From: Anita Gardner
Sent: 16 May 2019 09:44
To: Planning.Responses
Subject: FW: Planning Consultation on LU/109/19/DOC
Attachments: 6239_Shell Petrol Station_Littlehampton_SWM Report_Rev_A.PDF

With reference to our **Application No. LU/109/19/DOC – Shell Eastfield Worthing Road Littlehampton BN17 6LE**, please find attached all documentation and revised plans in line with your comments below:-

Engineers Comments Regarding Condition 3 and 4

Drawing No.
6239-20

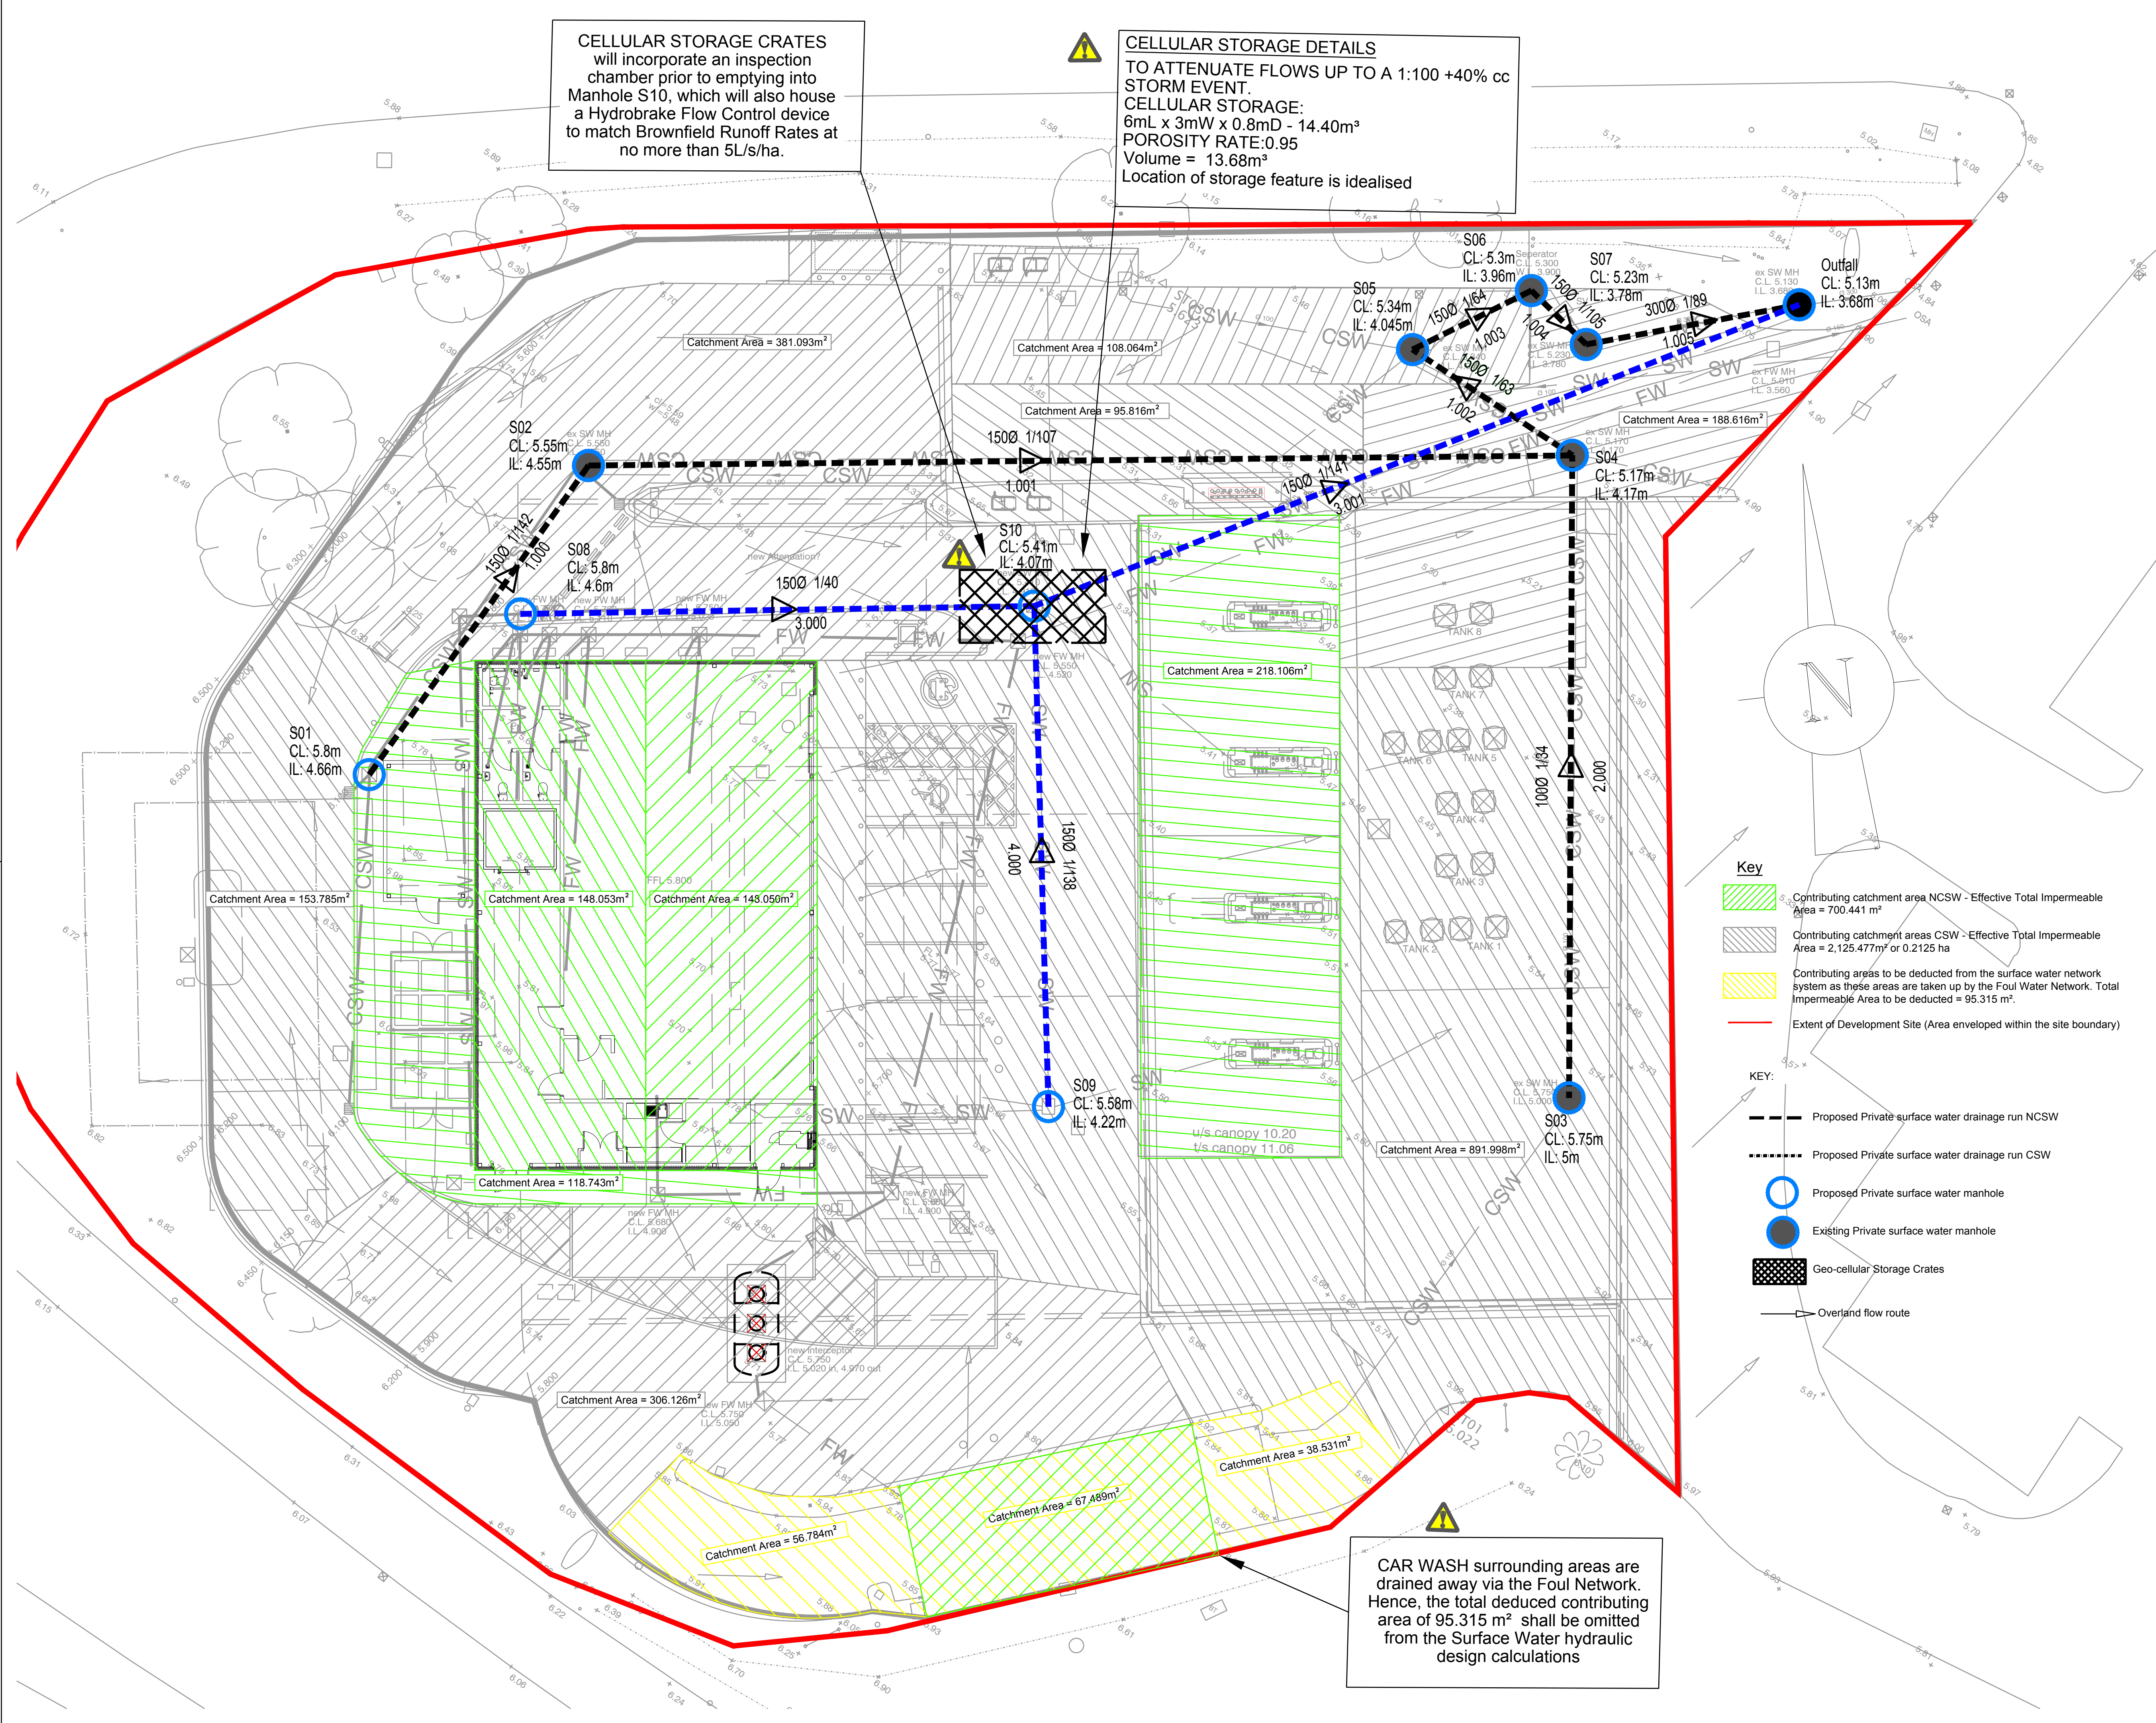
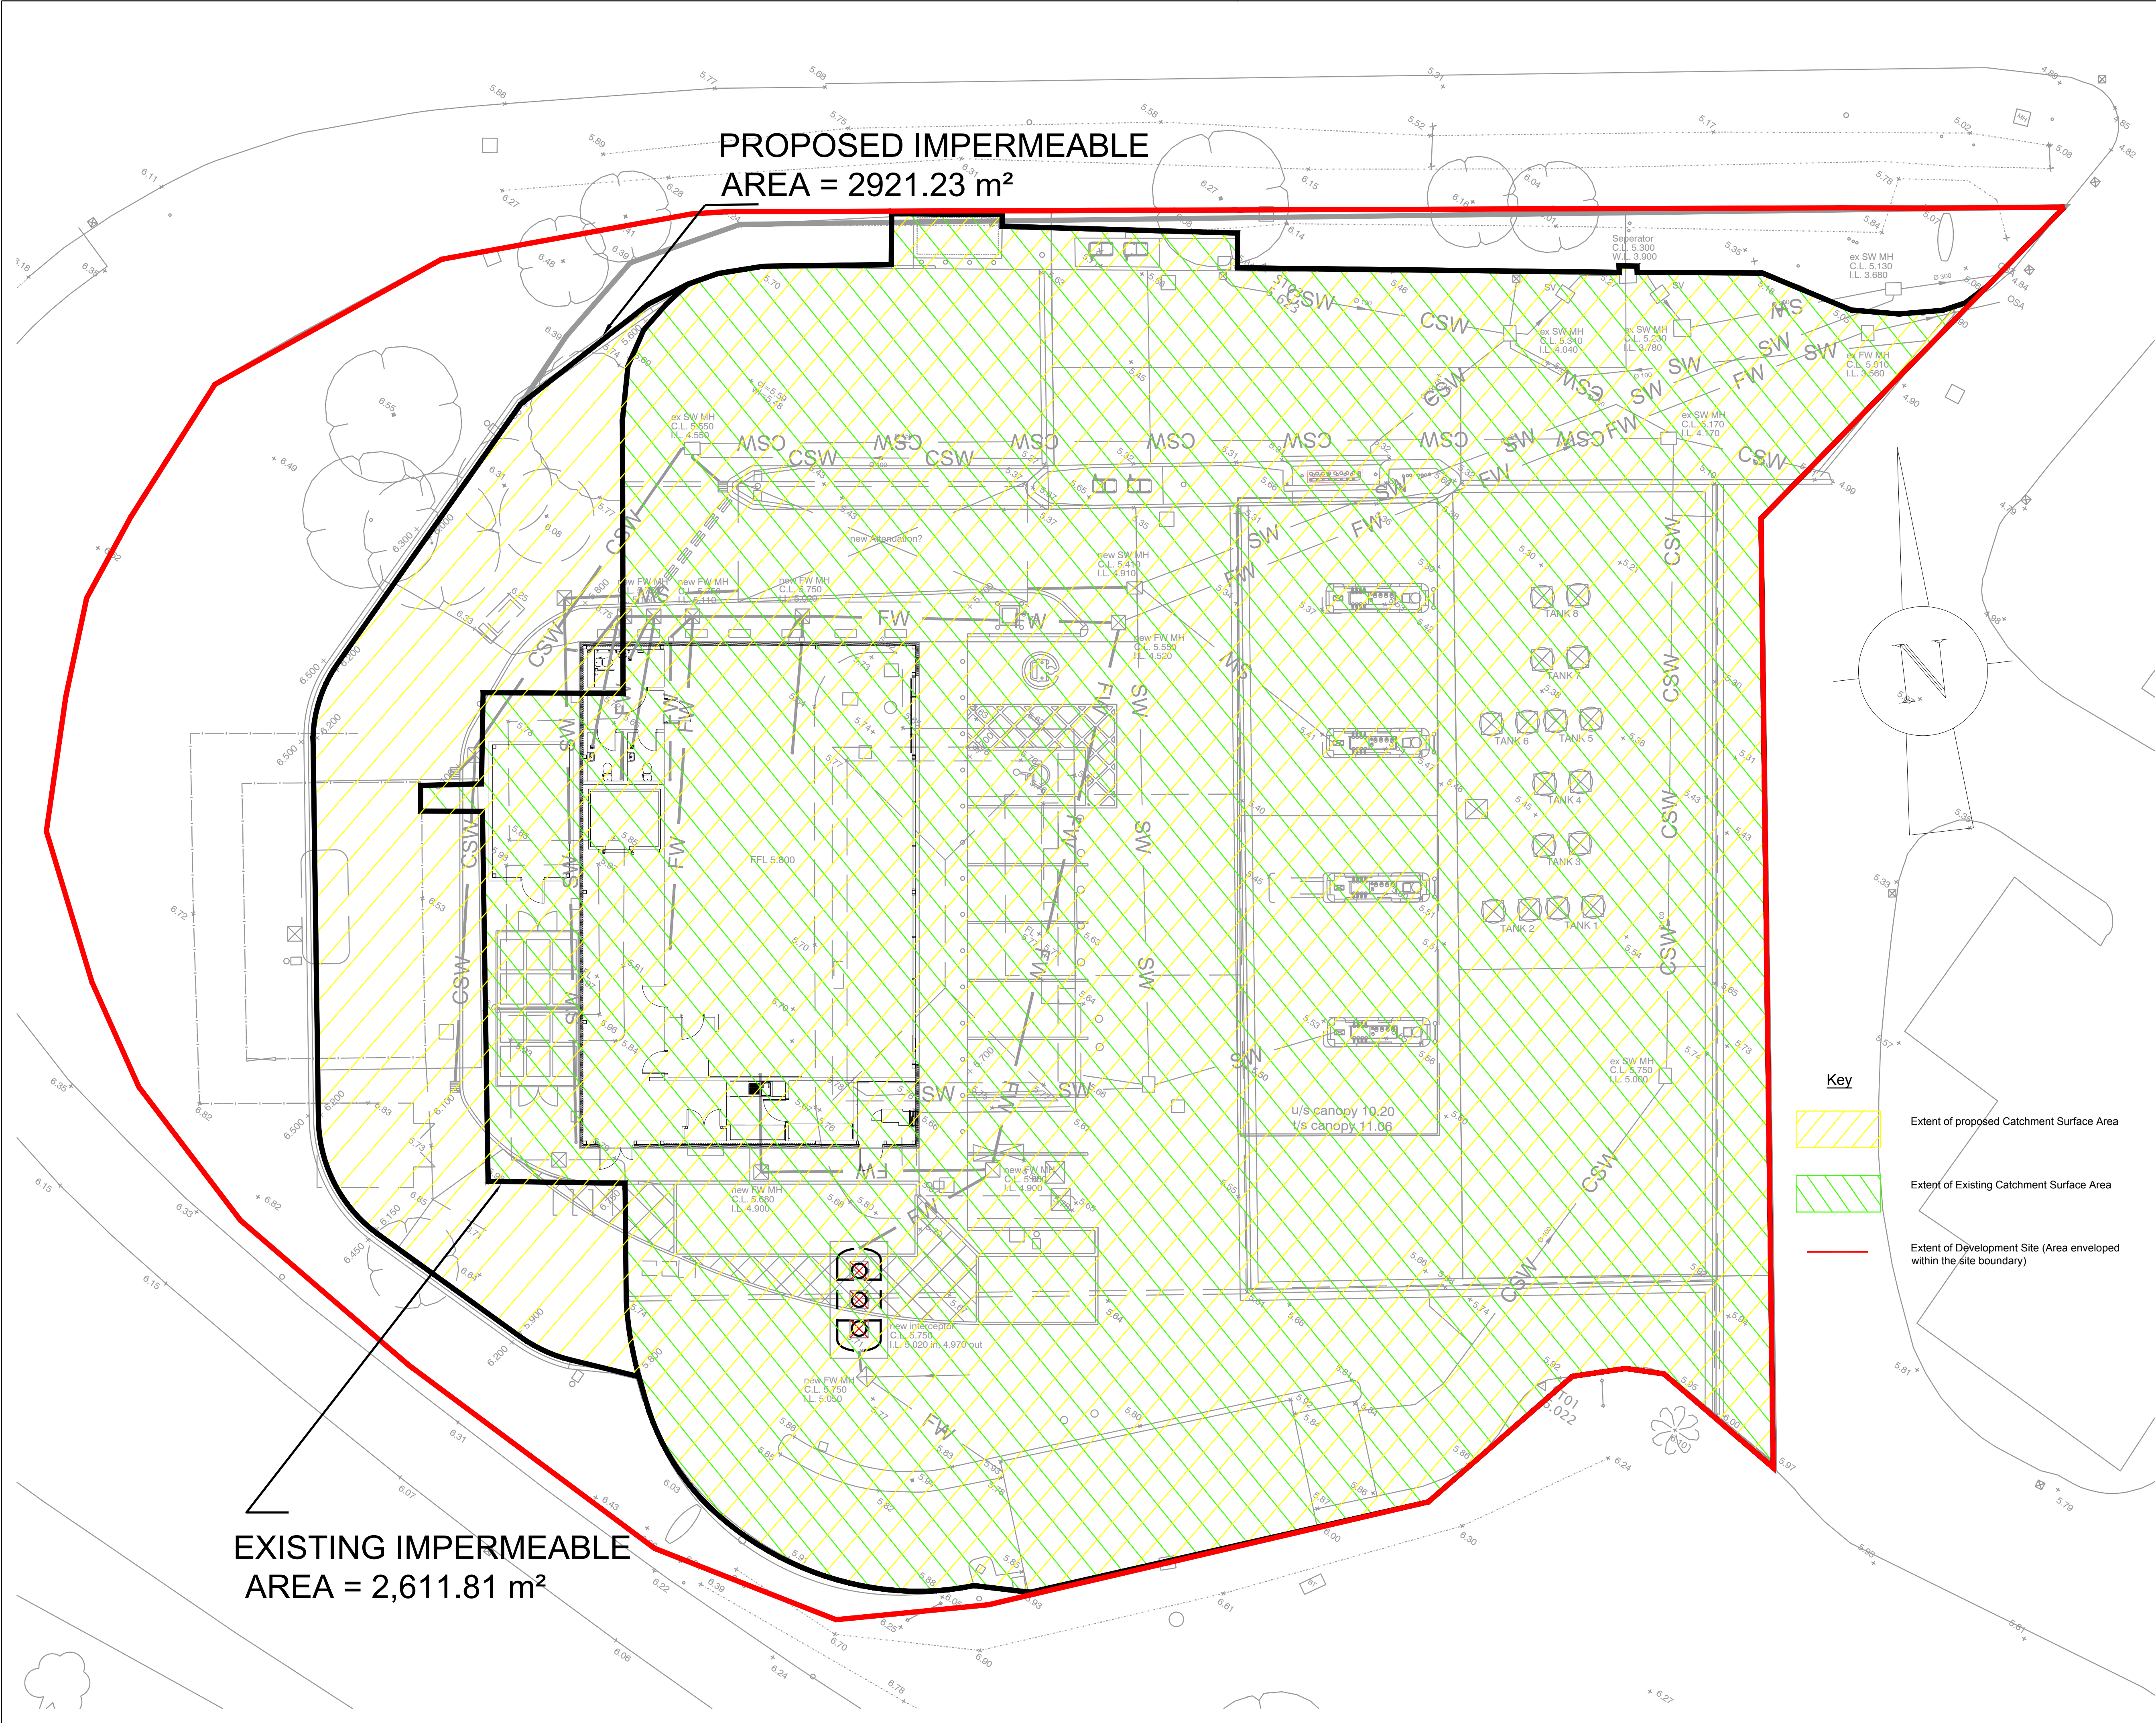
3. The layout plan provided is unclear in terms of differentiation of the two networks. Please revise line types etc.

4. Catchpit manholes should be provided upstream of attenuation tanks.

5. On the layout plan provided everything appears to be ending up discharging to the same location. Yet the text states that the non-contaminated surface water will be discharging to surface water sewer and the contaminated will be discharged to foul sewer. Please confirm and please provide clarity as to whether the proposals are to utilise an existing foul water connection.
